EPA comments on the EIS on exhibition for State Waste Services Arndell Park – Clinical Waste Management Facility (SSD 6761)

EPA comments on the air impact assessment for the expansion of the State Waste Services Clinical Waste Management Facility (SSD 6761)

EPA comments on matters relevant to waste management for the expansion of the State Waste Services Clinical Waste Management Facility (SSD 6761)

Figure 2-9: Site Layout

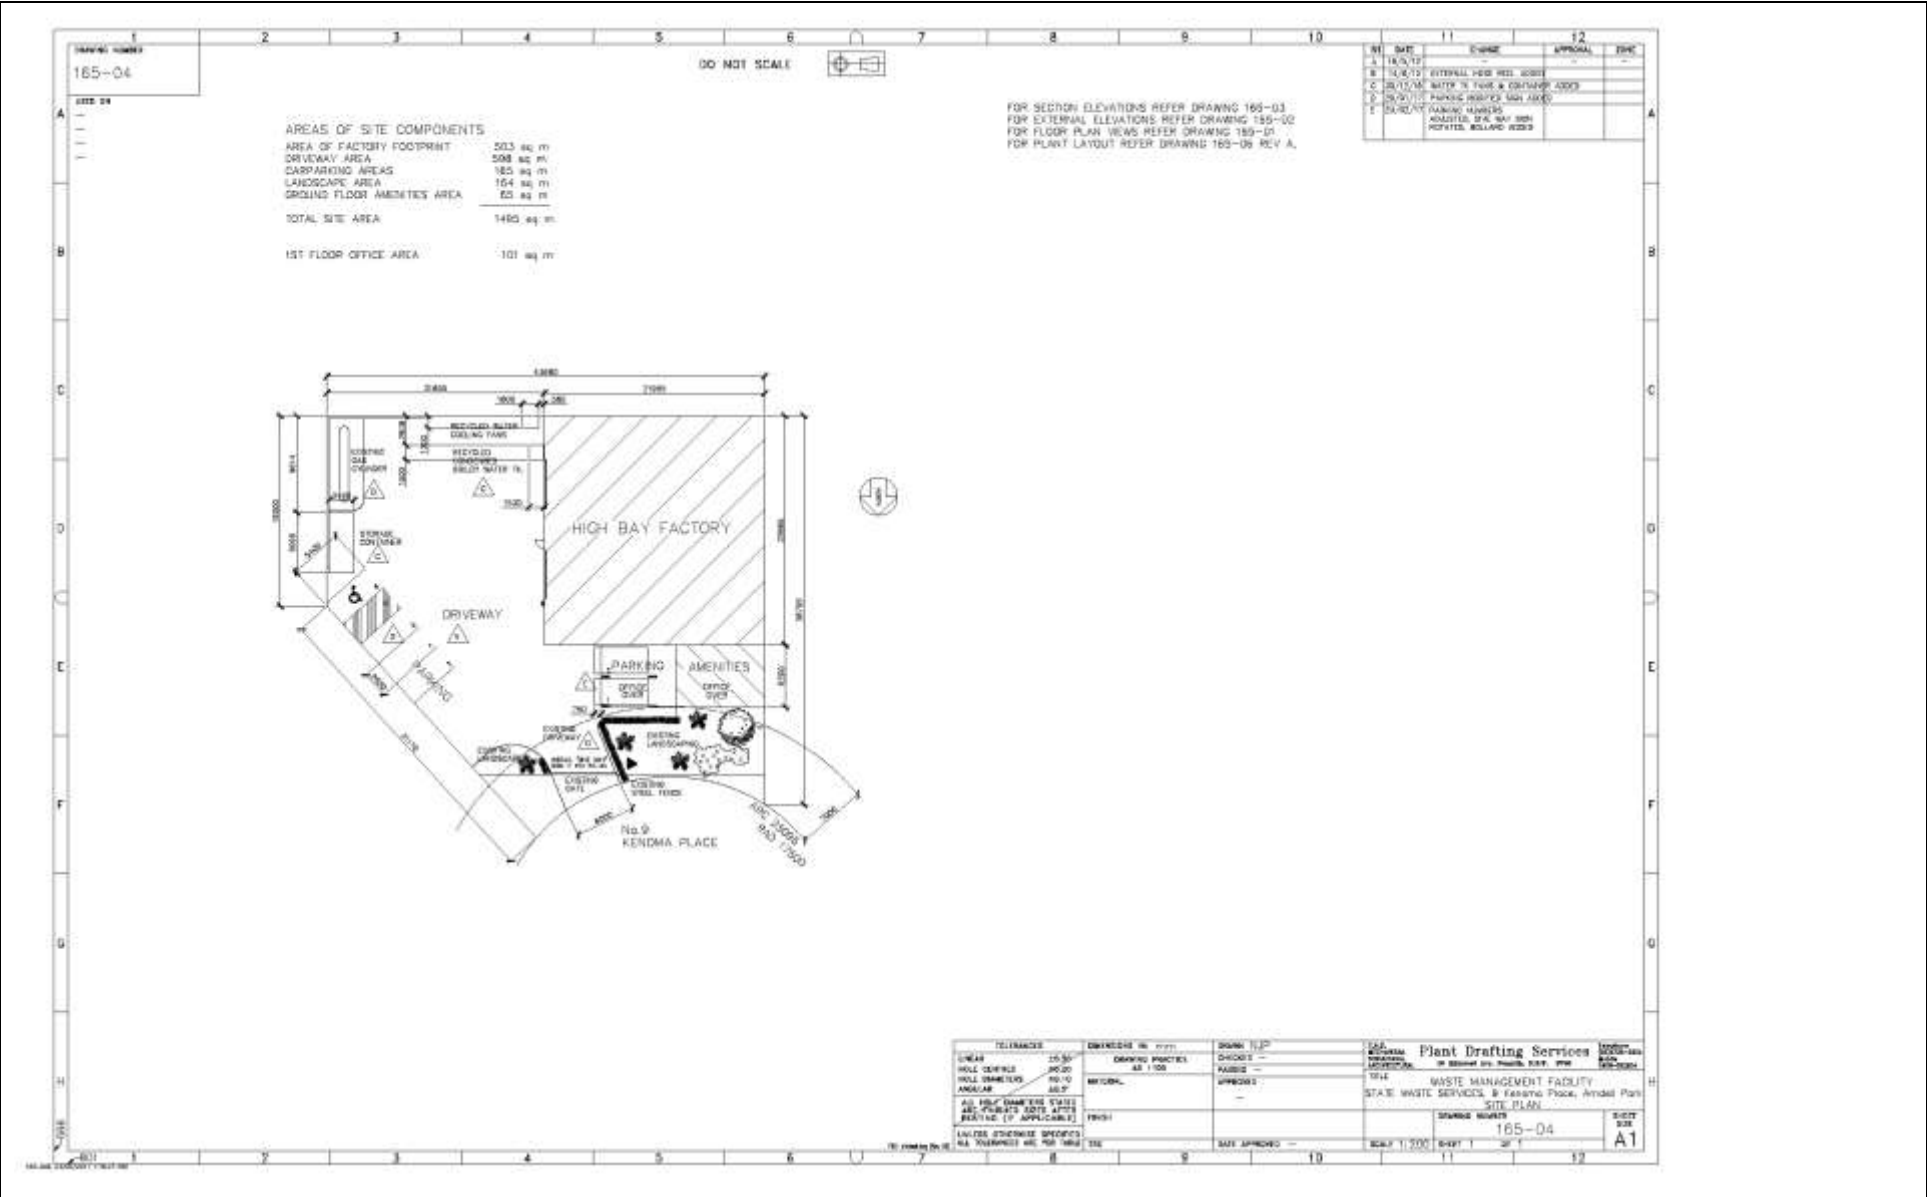
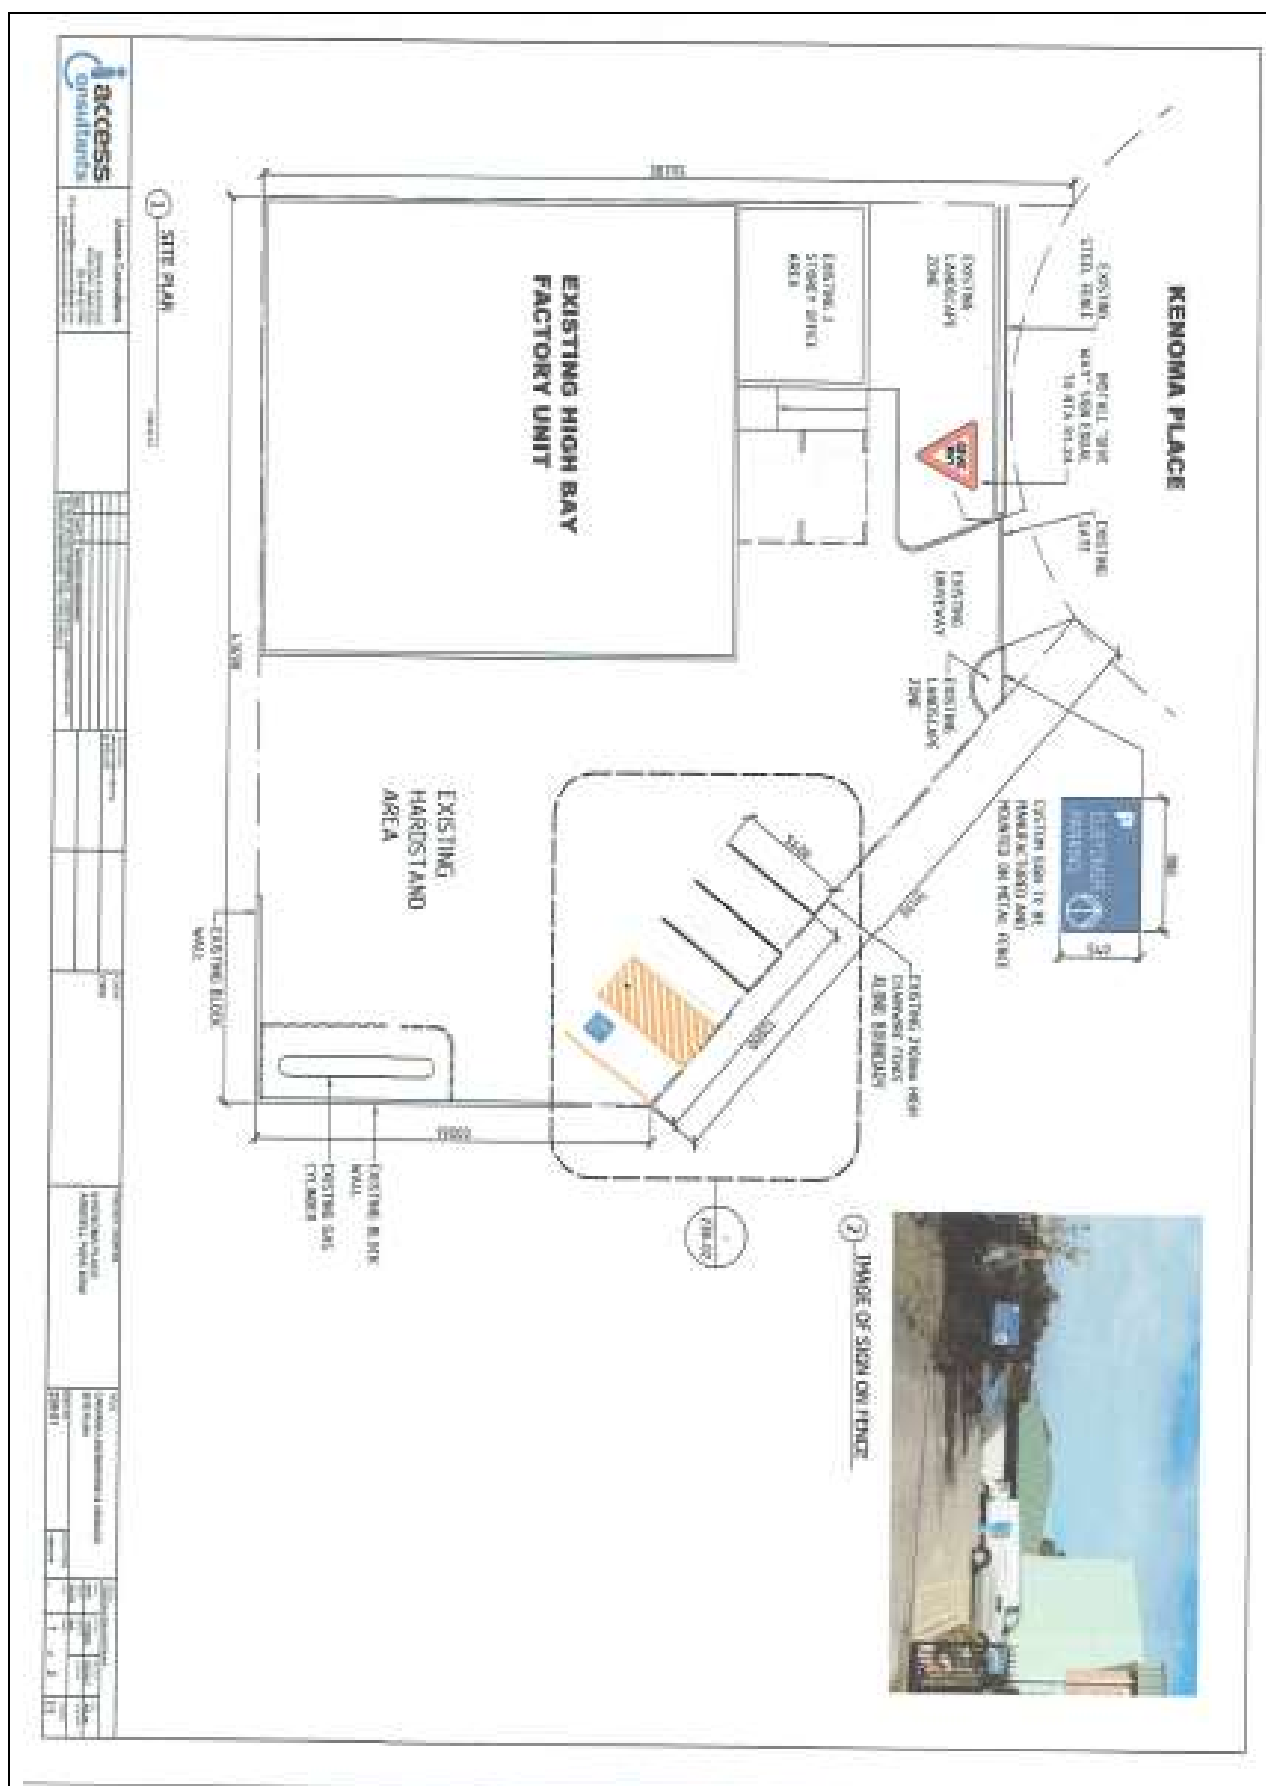
The AQIA only assesses odour sources at the site. There is a small boiler on site that was not included in the assessment. Emissions from the boiler will increase as a result of the proposal.

EPA recommendation: The AQIA should be revised to include all air emissions sources.

Figure 3-1: Annual wind rose (all hours) – Horsley Park 2015

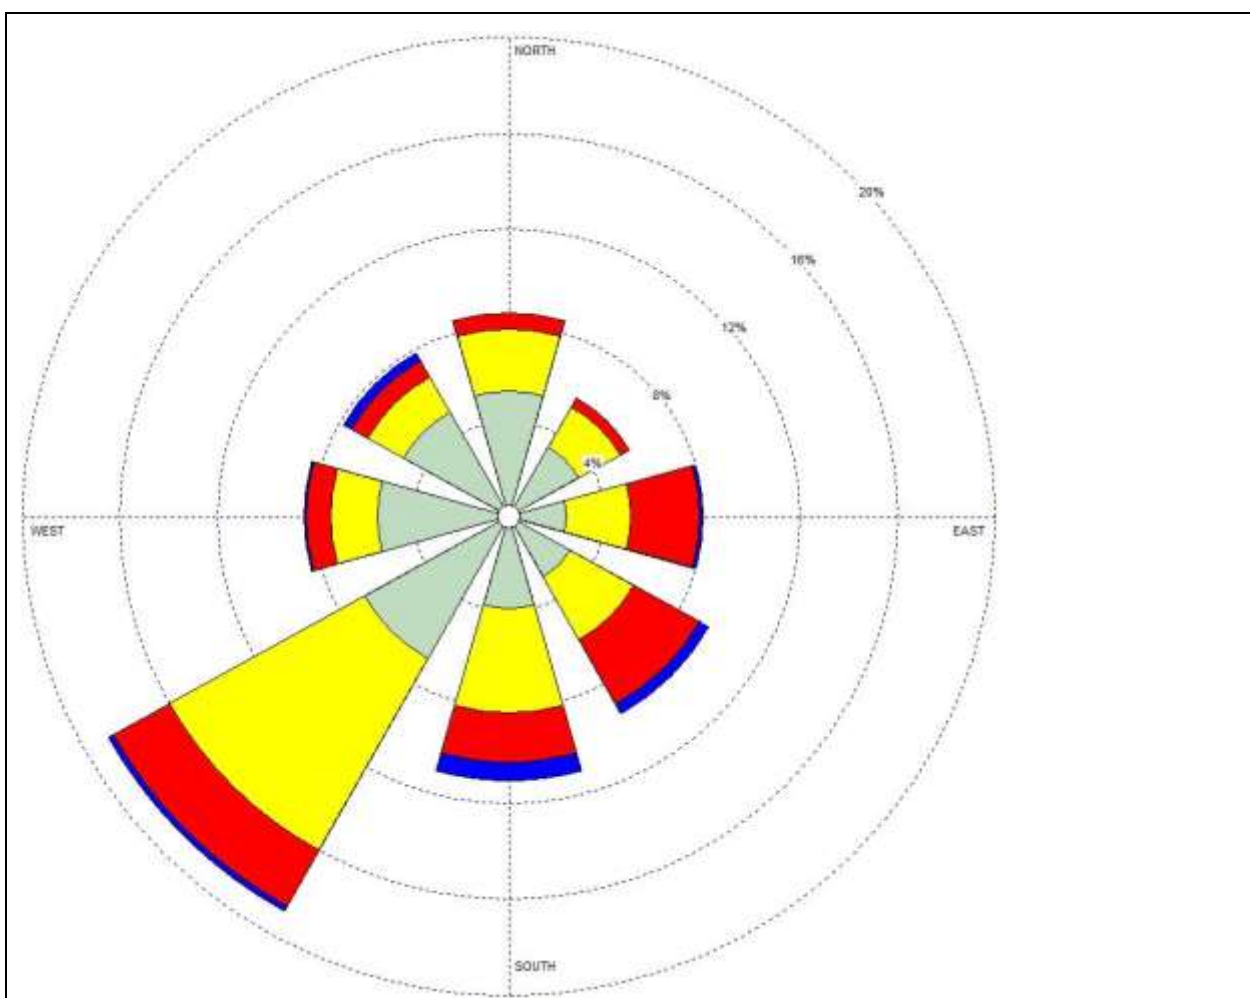
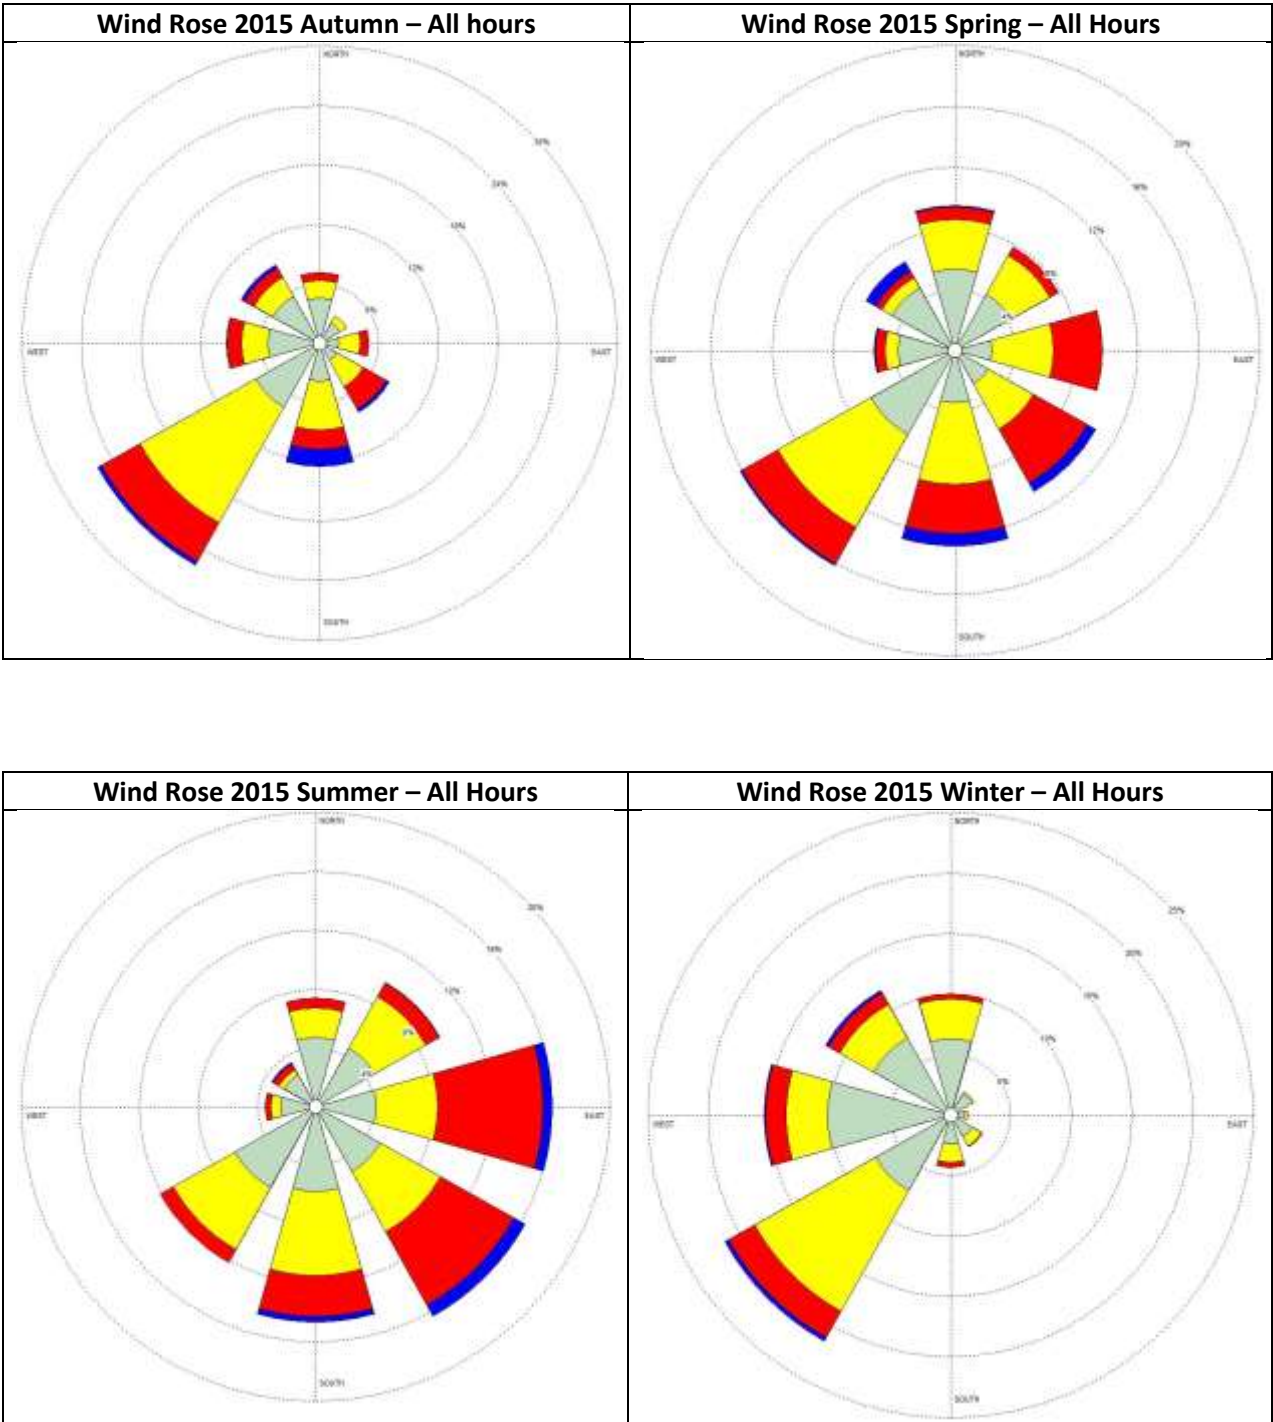
- c. The AQIA states that the year 2015 was chosen for analysis since it was the “most complete and recent dataset available from the monitoring station”. No justification that the year 2015 is a representative year is provided. Section 4.1 of the Approved Methods specifies that the meteorology data used in the assessment should be correlated against a longer duration data set of at least five years to show the data is representative.

EPA recommendation: The proponent should revise the AQIA to include details of how the meteorology data files were developed, details of calms and justification of the use of Aermet/Aermod, and justification that 2015 is representative of meteorology over a longer timeframe.
